Your ref: 2020 62/94307/E – Planning application, 1 Chadwick Crescent WF13 2JF. Erection of two storey side and rear extension and single storey front extension.

I write in connection with the above planning application. I have examined the plans and I am familiar with the site. I strongly object to the proposed development.

PROPOSED GROUND FLOOR PLAN
Scale 1:50@A1

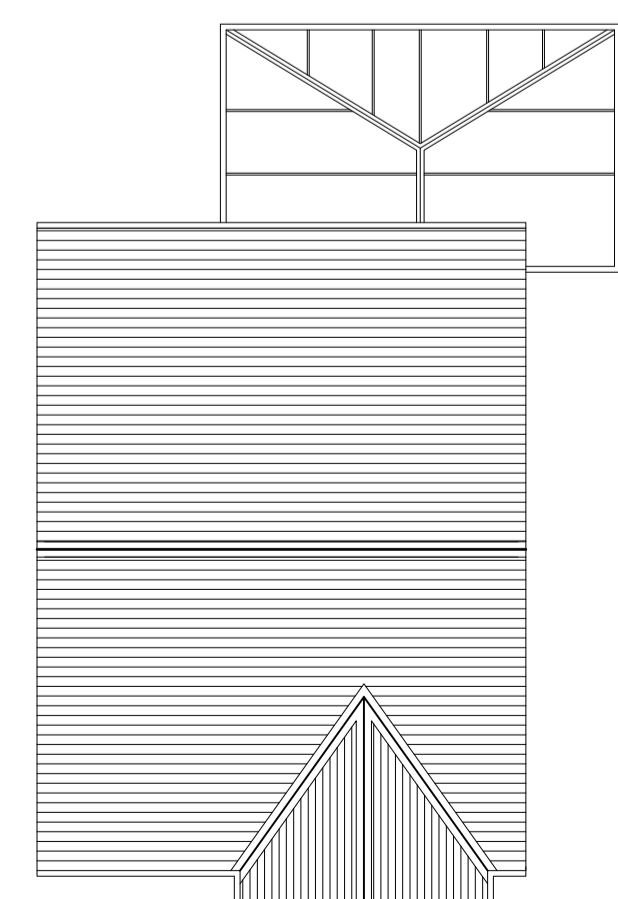
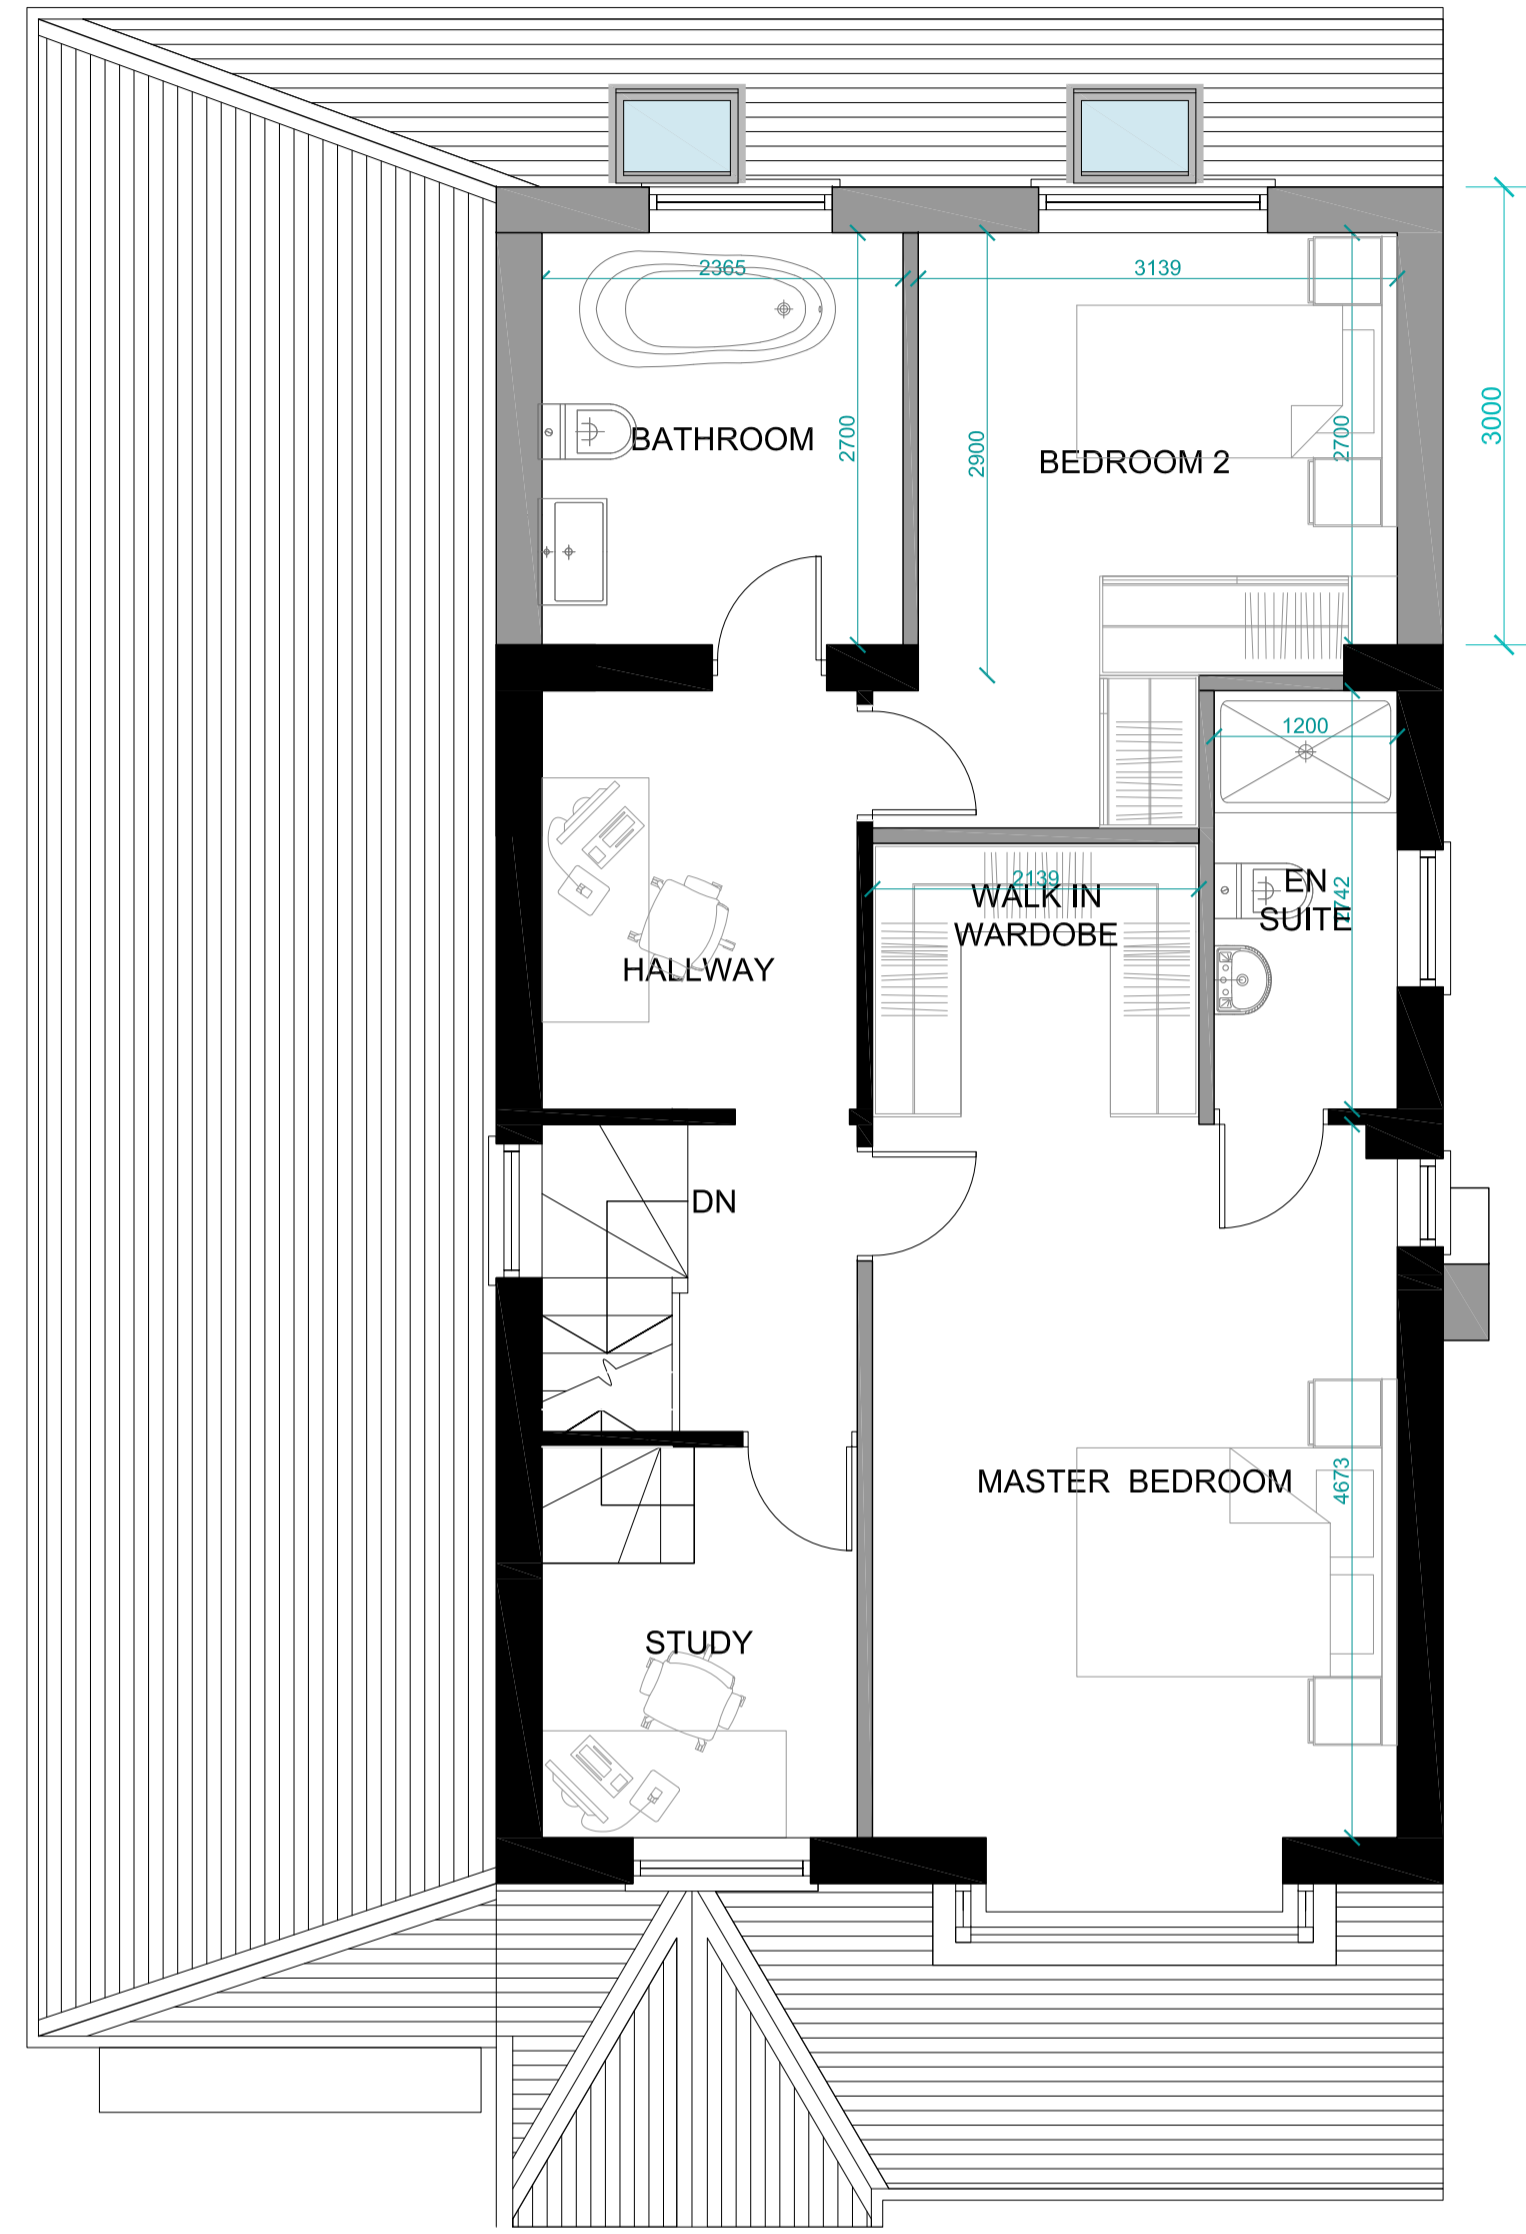
I note that the plans show a total of 6 windows along the side extension, two windows in the front porch extension and a further window in the proposed top floor. These windows would either be within the land of 15 infirmay Road given they are proposing to build on their land or looking directly onto the garden. Kitchen, Living rooms and bedrooms of number 15. Furthermore given the plans show they intend to build in the garden of. The fact that raised windows have been proposed does not alleviate these concerns given 15 Infirmay Road is on a higher ground and they would if opened have unobstructed view across the whole of the plot. This would infringe on Article 8 of the ECHR The right to Respect for private and family life.

**PROPOSED REAR ELEVATION**  
Scale 1:50@A1

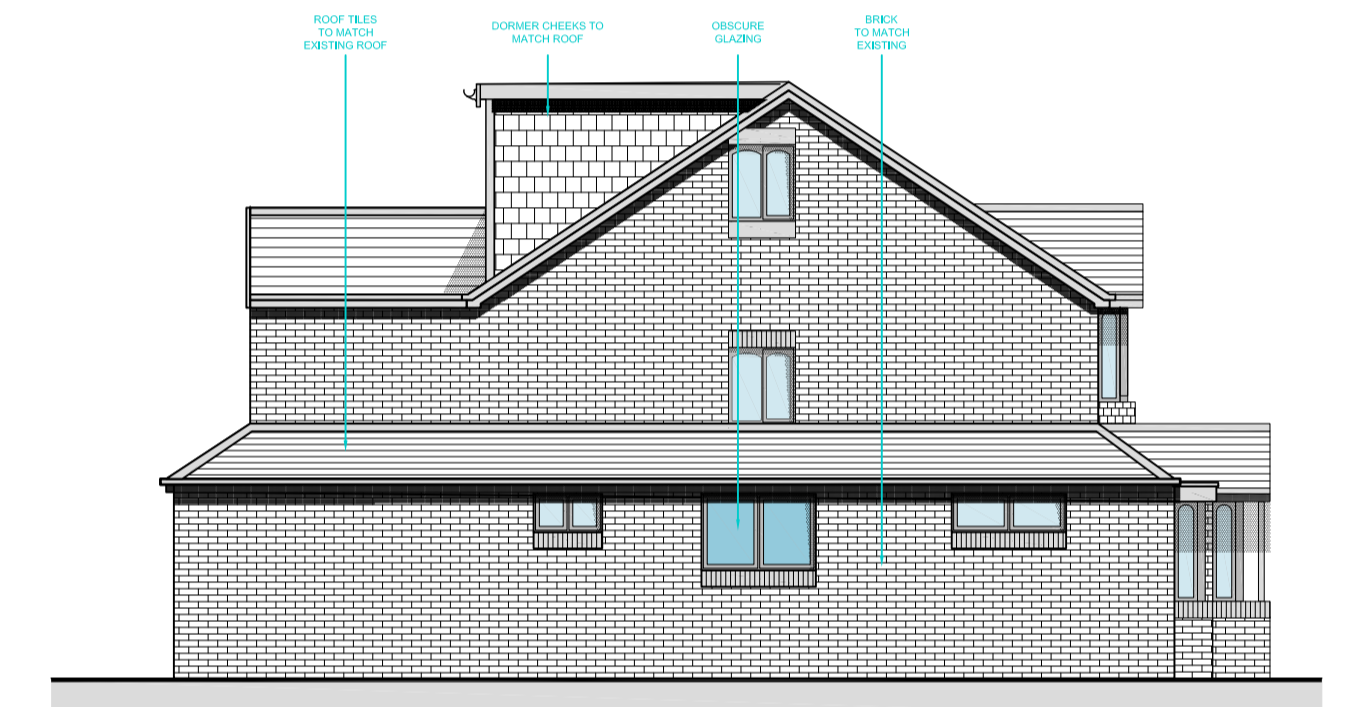
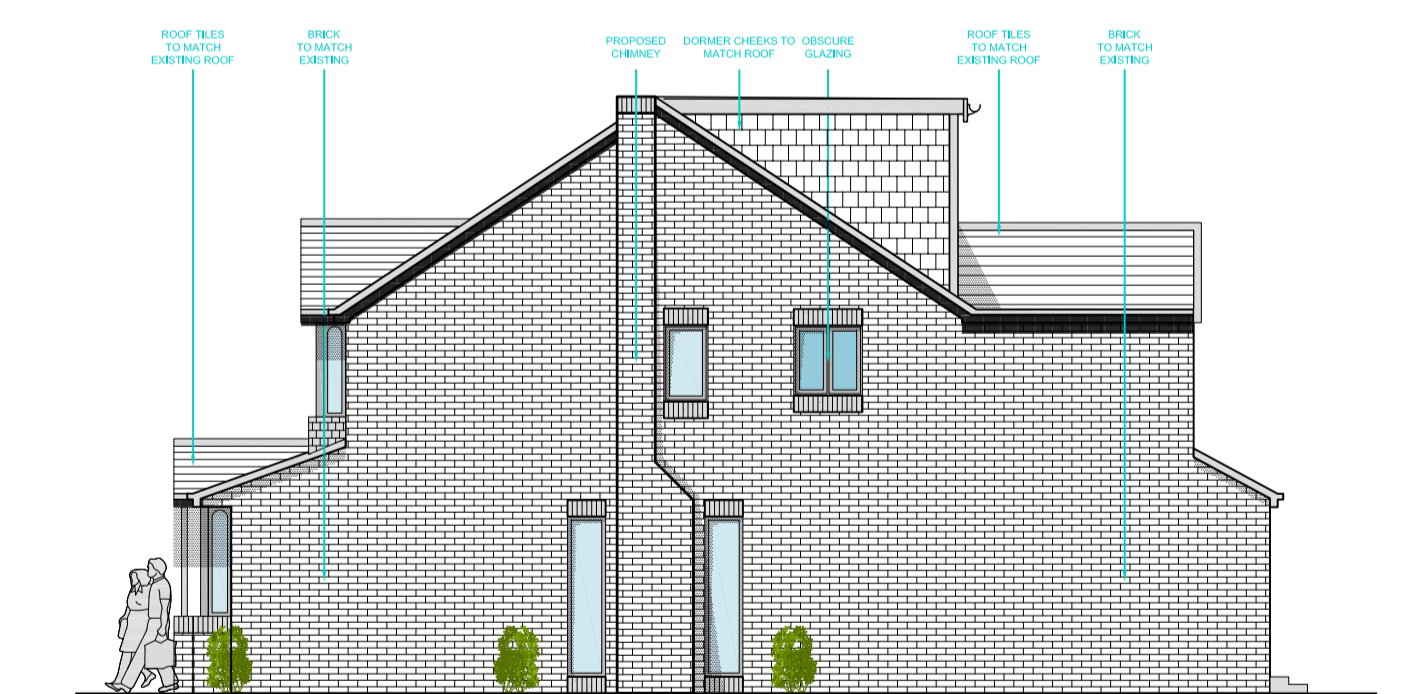
The height of the proposed development with particular regard to the side and rear elevations would create extreme overbearing, overshadowing and would result in a visually intrusive impact. In part this would be due to the close proximity of the dwelling buildings. Specifically, this exacerbates the adverse impact resulting from the proposals over dominance and overbearing which would be more profound once the kitchen is extended as intended.

**PROPOSED SITE PLAN**  
Scale 1:500@A1

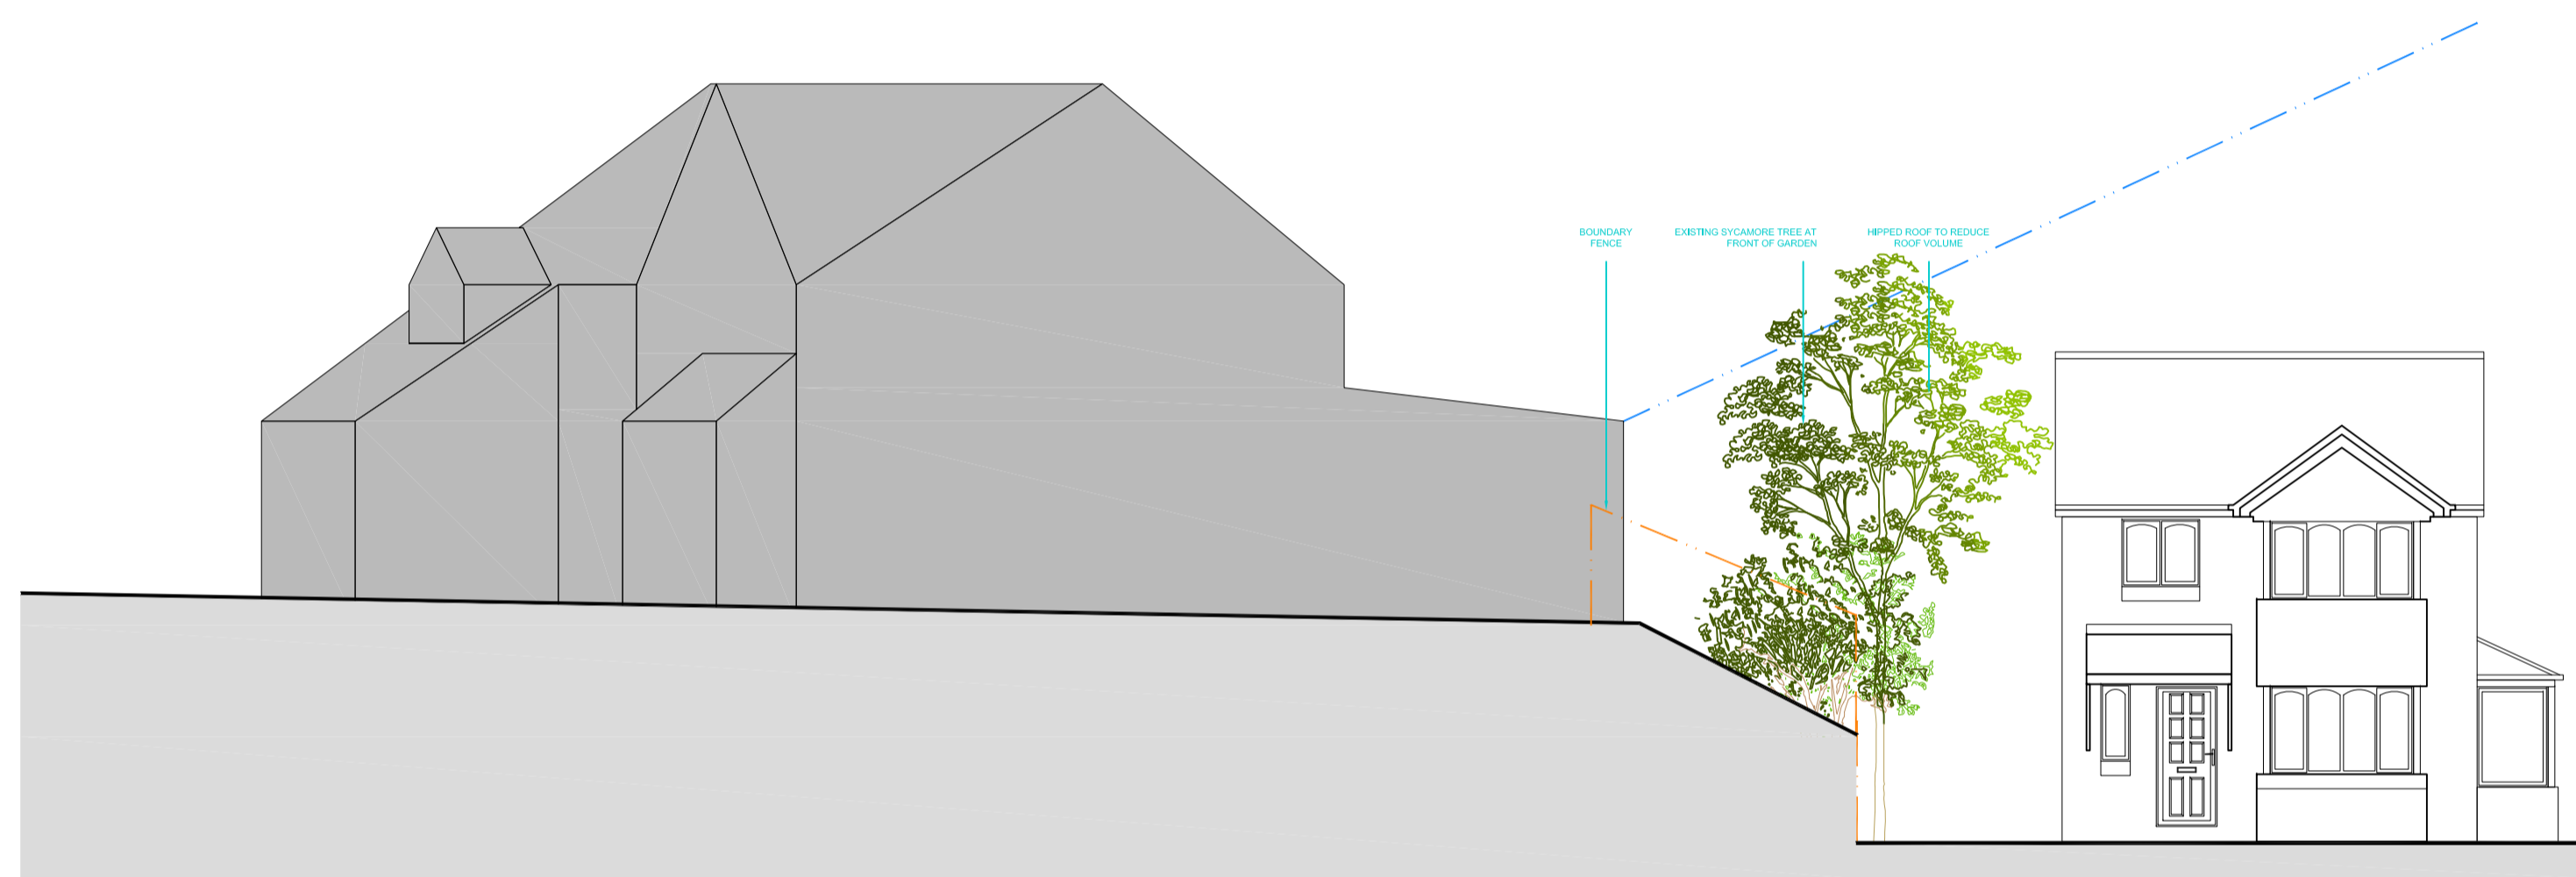
It is apparent from examination of the title deeds in respect of 1 Chadwick Crescent that the boundary line of the property runs in a straight line from the end of the garden, along the garage wall where it then meets the pavement. Having measured this part of the plot I can confirm that it extends to 2.6 meters in width. It is therefore completely unlawful for the owners to propose to extend the property on the side to 3 meters. The plans as submitted effectively mean that the owner of 1 Chadwick Crescent is proposing to steal the land of 15 Infirmary Road.

The wall and bushes on which they propose to erect the single story side extension are all located firmly within the boundary of 15 Infirmary Road. As such there are legitimate concerns that the plans submitted are not accurate in depicting the boundary line of the existing site.

A substantial mature Sycamore tree, protected by a Tree Preservation Order (TPO) is in the garden of 15 Infirmary Road. This tree provides significant amenity value to residents and users of both Infirmary Road and Chadwick Crescent. The proposed front extension is positioned either within the edge or very near to the edge of the tree's root protection area, I note this is now shown on the amended plans but it is not correctly marked on the site. Additionally, given the height and species of the tree, the

The proposed 14 meter side extension would almost entirely connect with the existing detached single garage, as shown on the submitted plan. To grant the application would inevitably result in the occupants of 15 Infirmay road having to look directly onto 20 meters of brick walling in length. This would be at a distance of less than a few centimetres from the garden and at most several meters from habitable room windows. This would decimate the visual amenity currently afforded to the occupiers of 15 Infirmay road and other neighbouring properties.
